Subject: **Request for Modification to Individual Section 404 and Section 401 Water Quality Certification** for the Winston-Salem Northern Beltway from US 52 to US 311 (New Walkertown Road), Forsyth County. Federal Aid Project No. NHP-0074(213), TIP Nos. U-2579D, E& F. Division 9.

The North Carolina Department of Transportation (NCDOT) requests modification to the existing Section 404 Individual Permit and Section 401 Water Quality Certification for the proposed Winston Salem Northern Beltway from US 52 to US 311 (TIP U-2759 D, E, and F) in Forsyth County. This project is currently under construction.

Permit Impact Site Modifications

MATCHLINE -L- STA 309+50  
 SEE SHEET 22

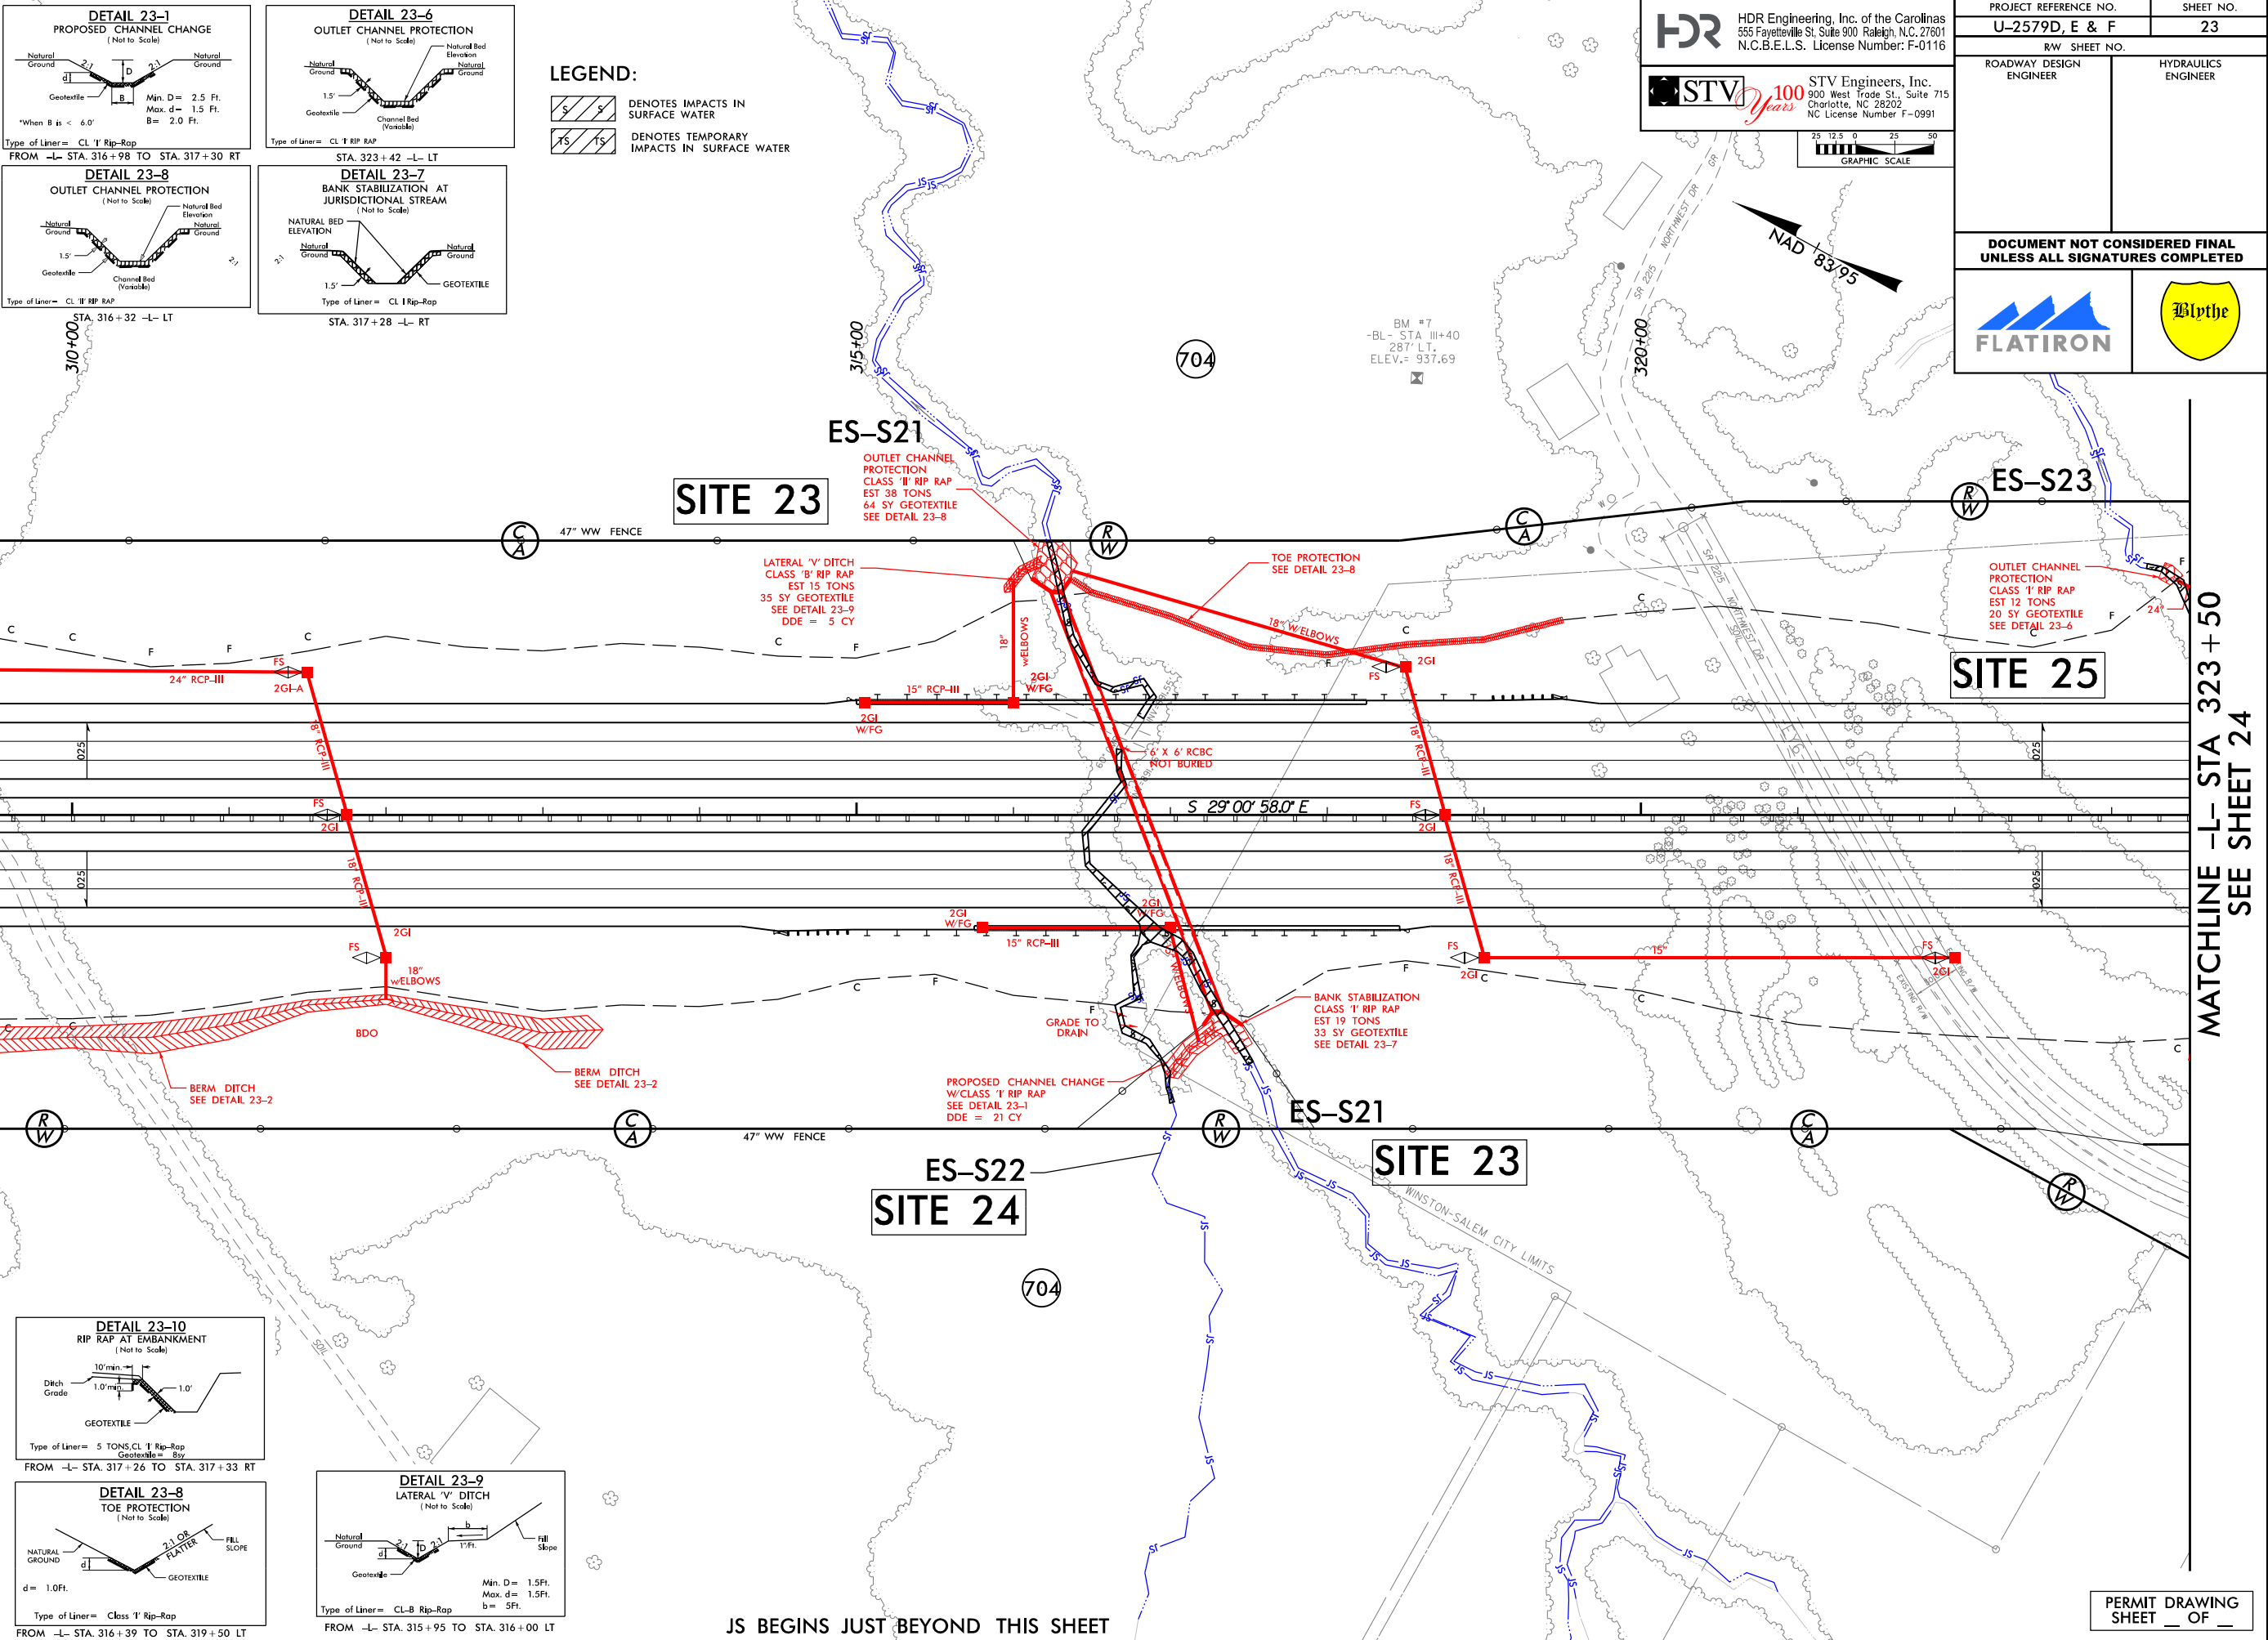
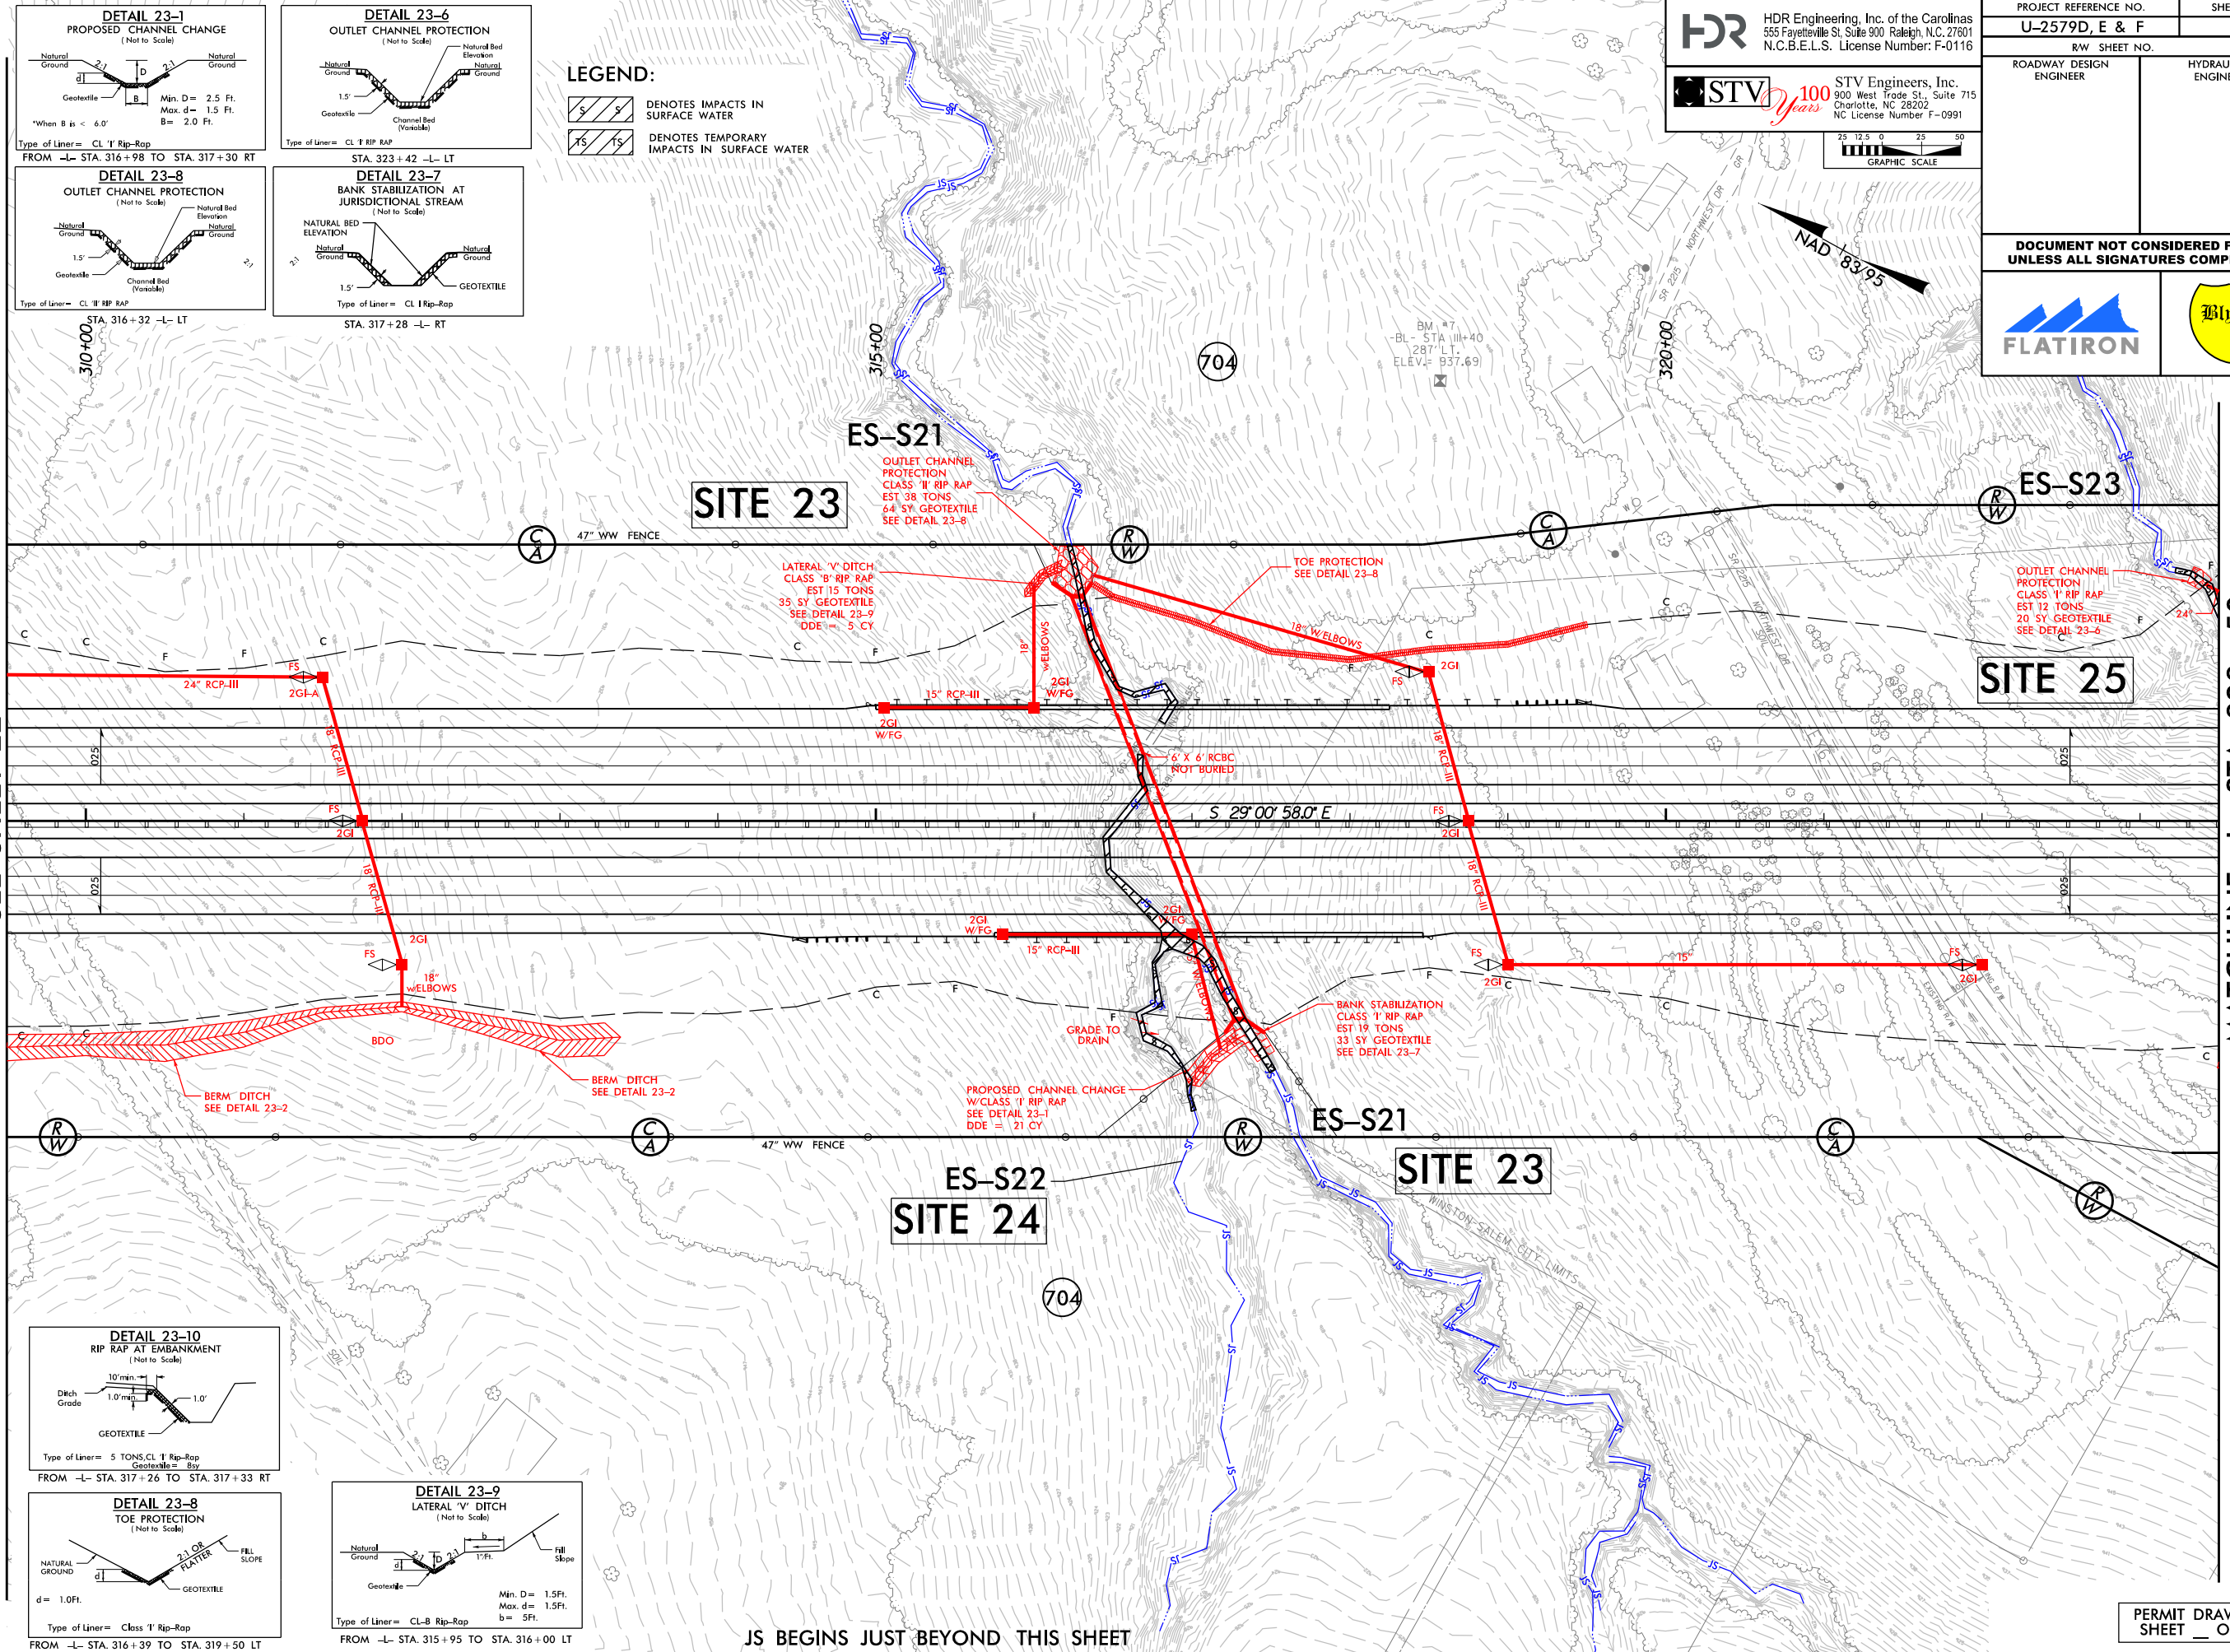
Site 23 (Sheet 23): Site 23 impacts changed as a result of the final design of the 6x6 RCBC in which the culvert length was increased from preliminary plans. When reviewed with the previous modification the new culvert length resulted an increase in permanent impacts by 15 linear feet for the RCBC and by 2 linear feet for bank stabilization. The temporary impact at this site was reduced by 11 linear feet. There will be a total of 363 linear feet of impact due to the RCBC, 28 linear feet of bank stabilization, and 10 linear feet of temporary stream impact at Site 23.
